Pagham Beach (Holdings) Ltd

Application ref: P/84/12

New access road and amendment to curtilage of plot 1

Amendment to approval P/44/09 (re-submission, following Refusal P/30/12)

PLAN NO 598/10B  
SCALE 1:200  
DATE 03/09

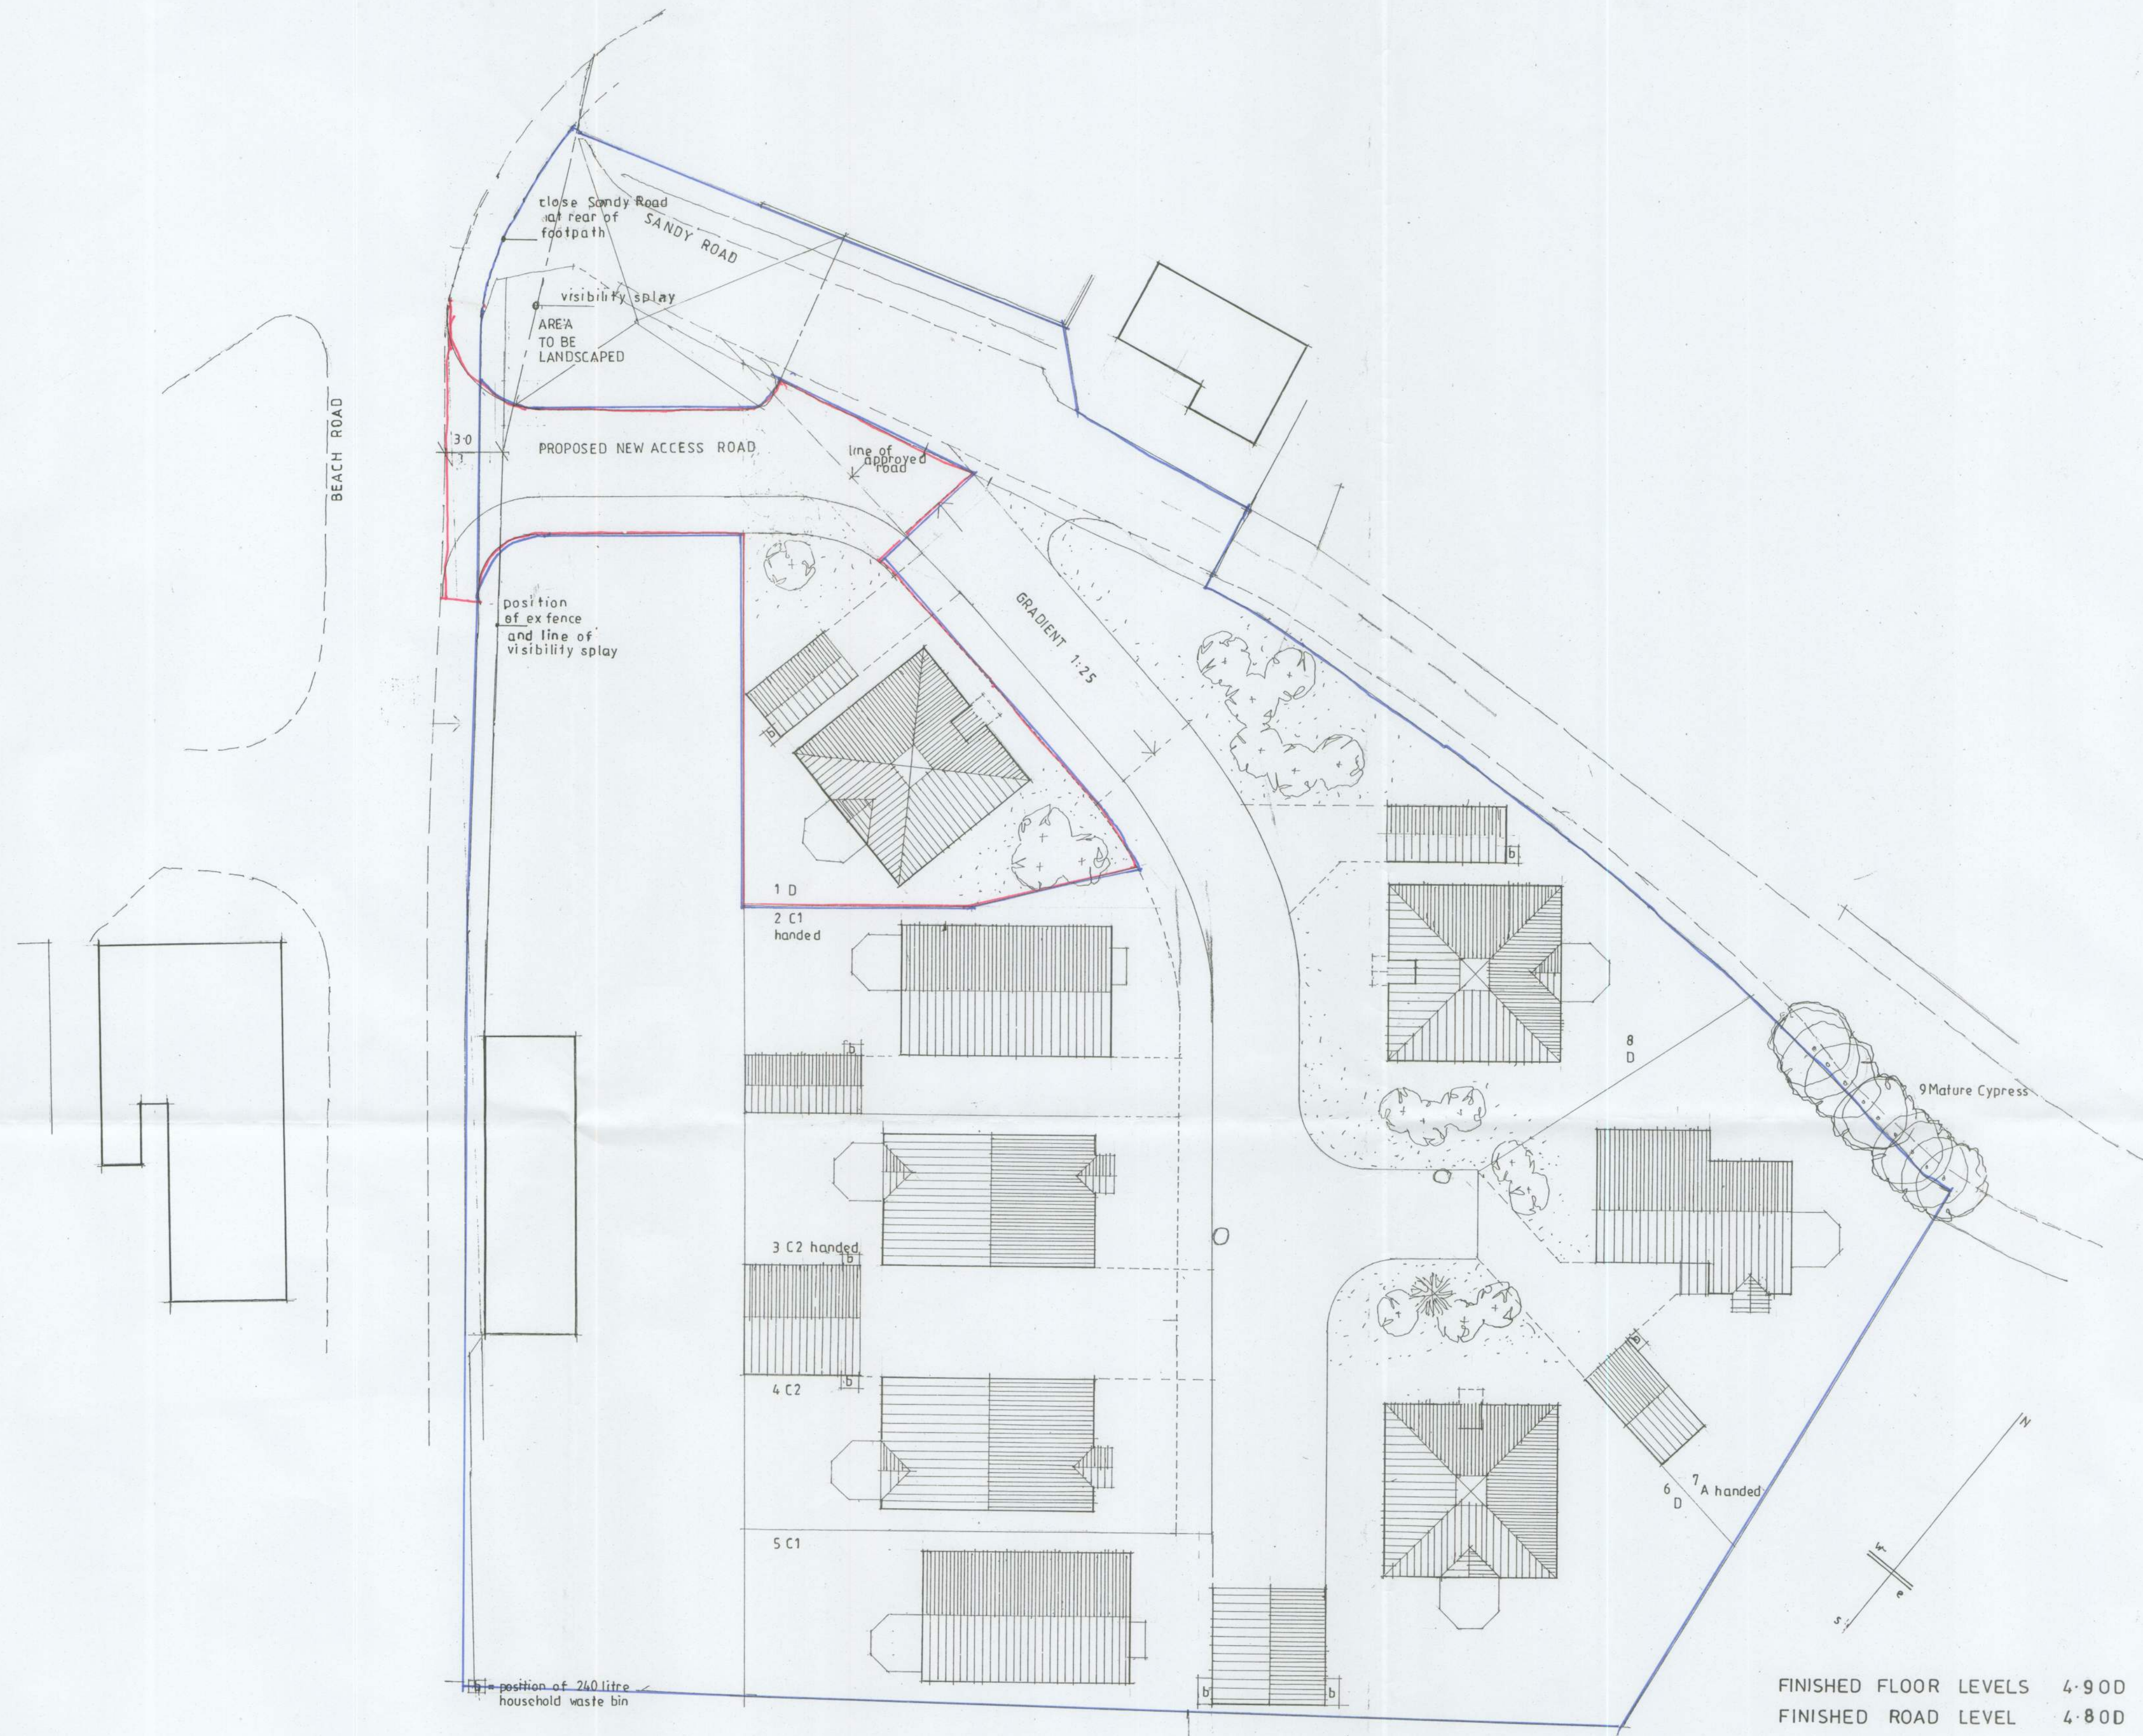
The Applicant has not demonstrated the vision splays at the proposed new junction are improved or indeed has not even defined the proposed vision splays at the new junction or included these within the Application Site. In the view of the Company the Application is therefore defective, and again should be Refused.

As previously referred to, the junction of the remaining section of Sandy Road to the new estate road is not defined within the Application and this information must be included to ensure that the new junction is adequate and safe and that road users and pedestrian safety is not compromised. Without this information, the present Application is defective and should be Refused.

Also, as previously advised, the construction of the new estate road and its junctions is not defined, and this information must be provided in order that the matter may be fully considered.
